Objection to Planning Application

158 Hawthorne Way, Shelley, Huddersfield, HD8 8PX

Application: Change of use of garage to treatment room for hairdressing, including installation of bi-fold doors
(Agent ref: 383-26-R1)

Council application reference: 2026/62/91926/E

Drawing Title: LOCATION PLAN

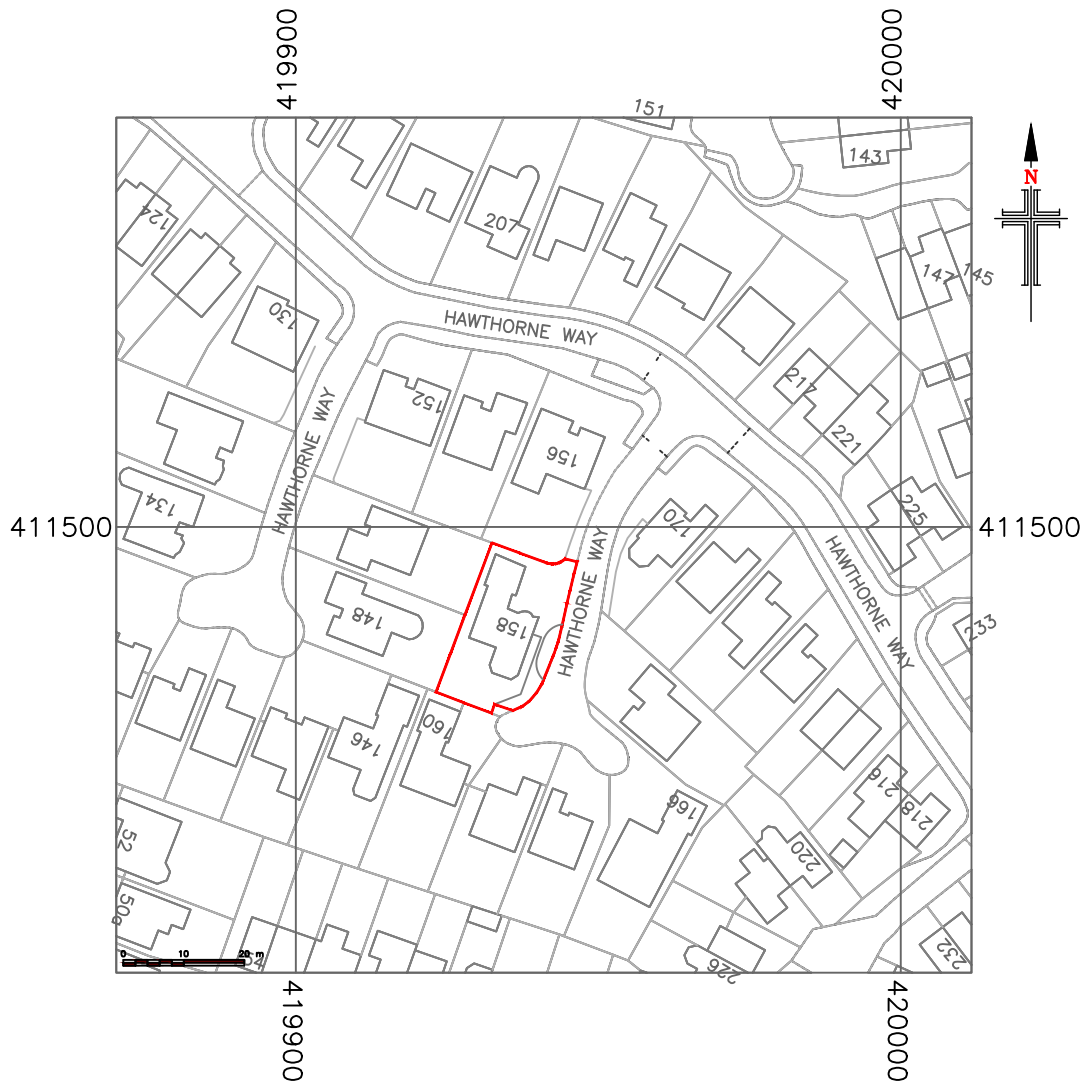
The submitted plans do not seem to be official Land Registry documents as there's no reference number and a 'wishful' line has been drawn in red around the area the applicant believes they own or they want for their business & plans.

The applicant's below submitted plan has been altered to include the service strip and parking bay 'as theirs' when it's clear the 'thick' boundary line is to the property fence (in yellow), which then continues down the same trajectory to the wall of 156 below... I dispute this service strip now belongs to 158.

In the plans, it's states that a solicitor's letter suggests the parking bay does indeed belong to the applicant. Yet there is no proof of title, or any record of transactions to say when this strip of land, the service strip, was purchased, by whom and for how much. The previous owner also tried to 'land grab' the bay and strip by attempting to fence it off and make it a part of his garden. This didn't happen for the same reasons stated above.

Proposed Ground Floor Layout
Scale 1:50

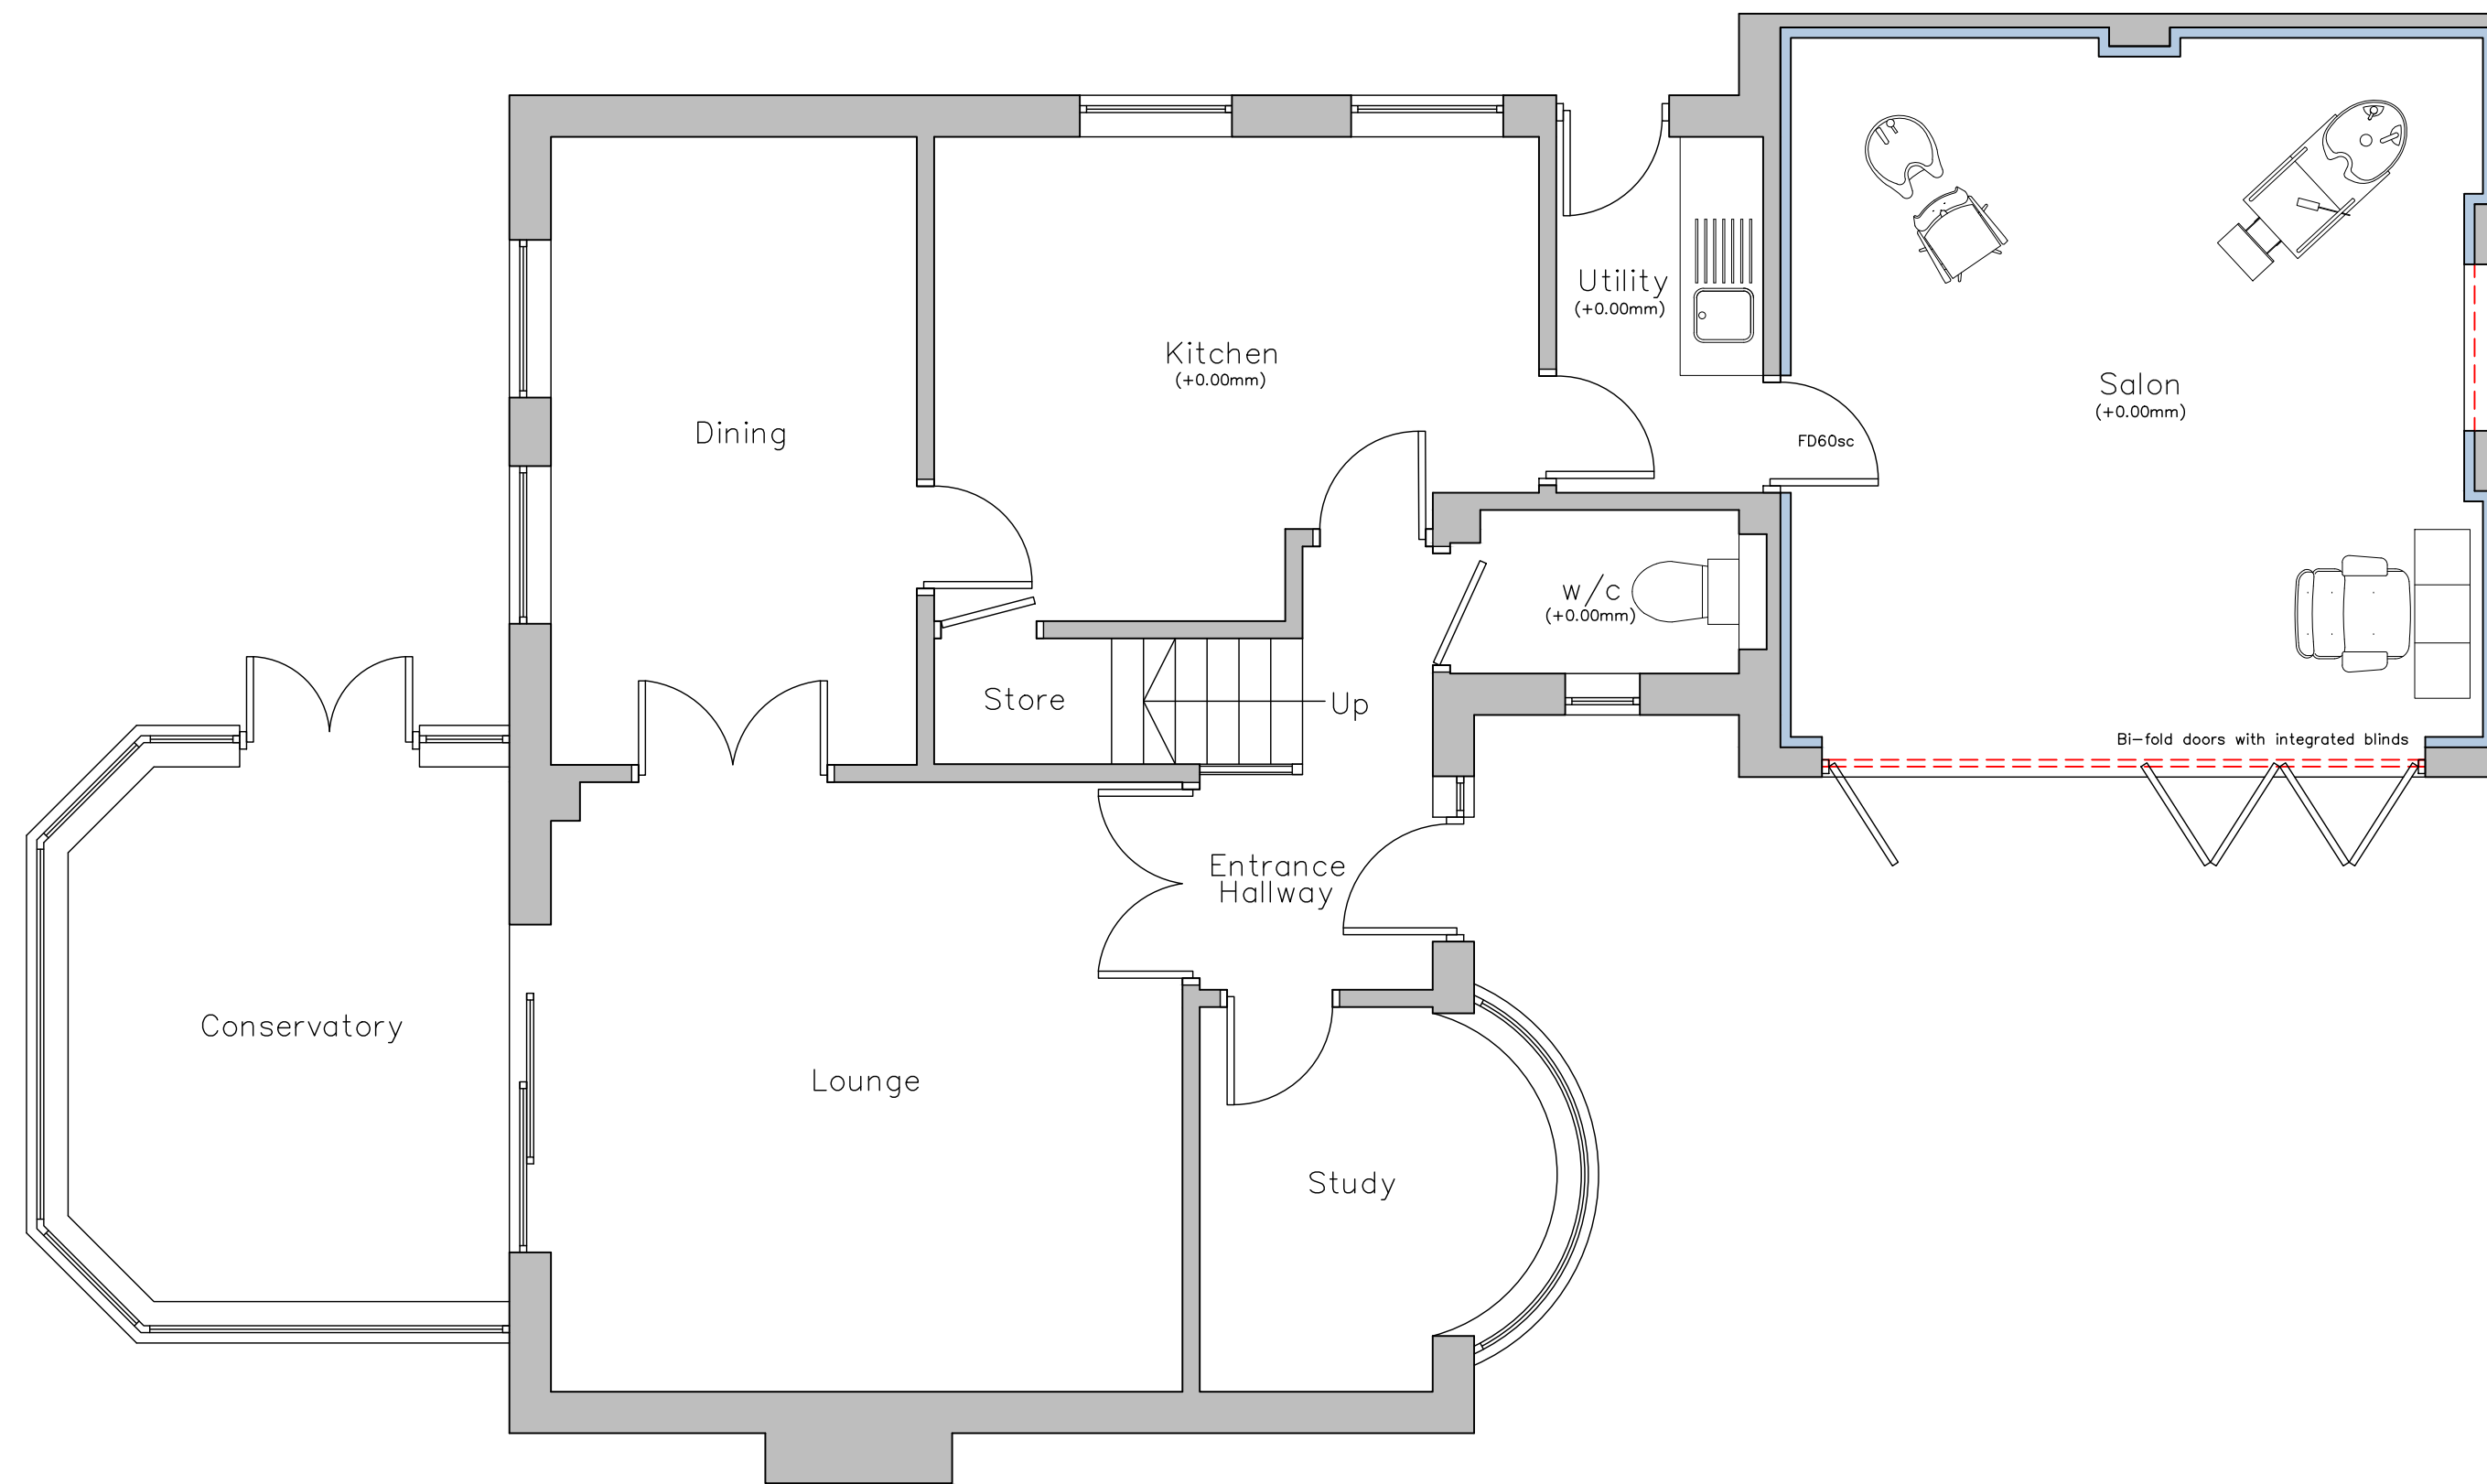
If this proposed business is a 'one-in-on-out' as stated in the plans (though from observations already, this is most definitely not the case), why would there be a need for a large treatment room with several chairs and wash stations?

Proposed South East Facing Side Elevation
Scale 1:50

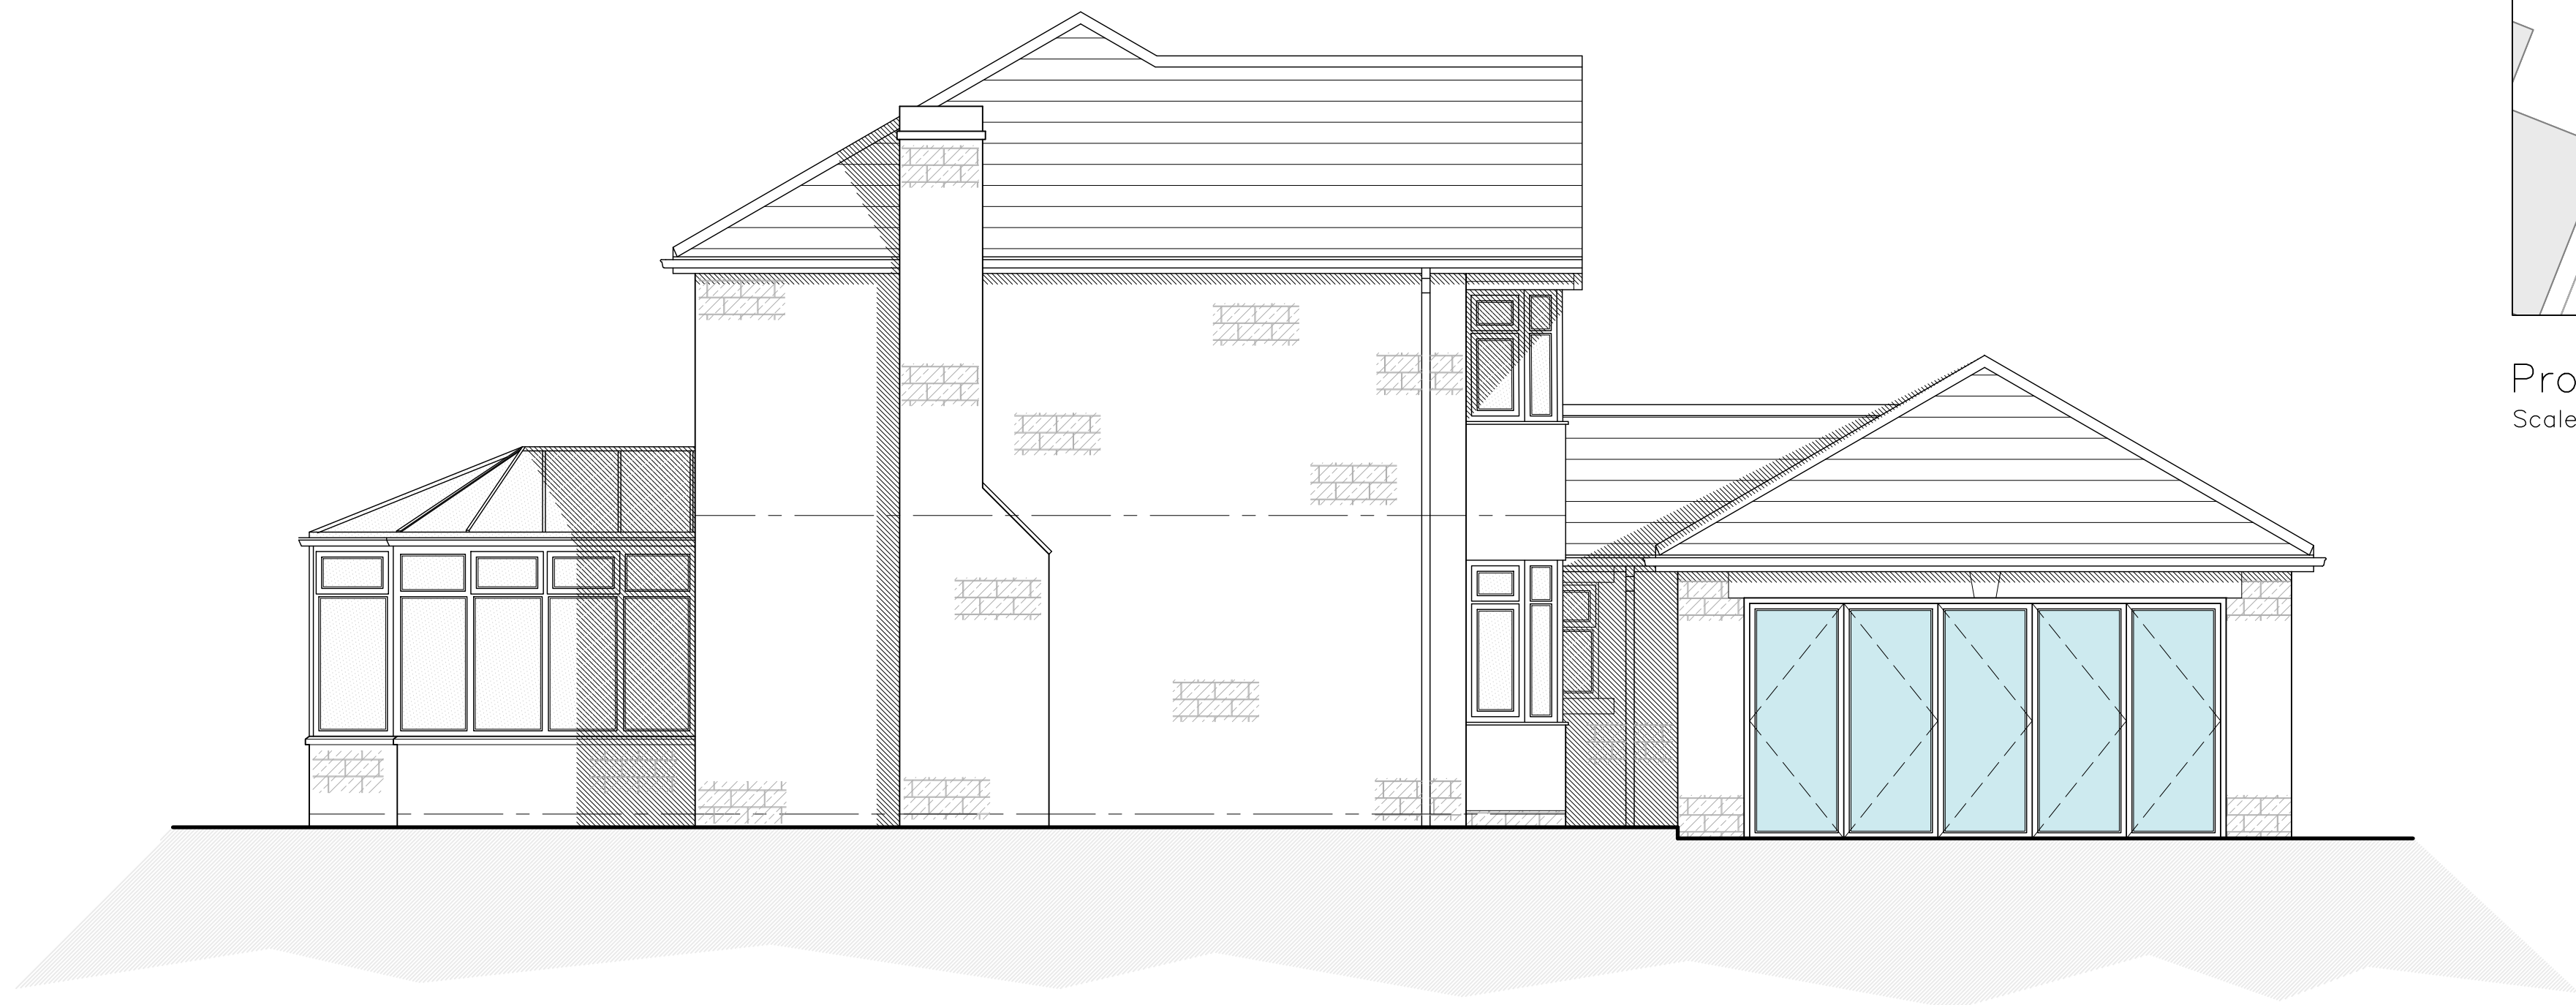
If the garage is converted with Bi-Fold doors, this would mean the applicant, clients and anyone in that space would then be looking directly into my living space and main bedroom.

If the planning consent is granted for the Bi-Fold doors, I would suggest frosted glass to maintain the privacy I've enjoyed in my own house for more than 16 years. I do not want to be watched by strangers coming and going as I go about my day in my own home.

Adding Bi-Fold doors would seem inappropriate for the area, and all the other conversions on the estate, as it stands. I also include myself in that, as I converted my garage in 2010 with consent and conversations with neighbours about my plans and their blessing. I ensured the conversion was sympathetic to the cul-de-sac, and
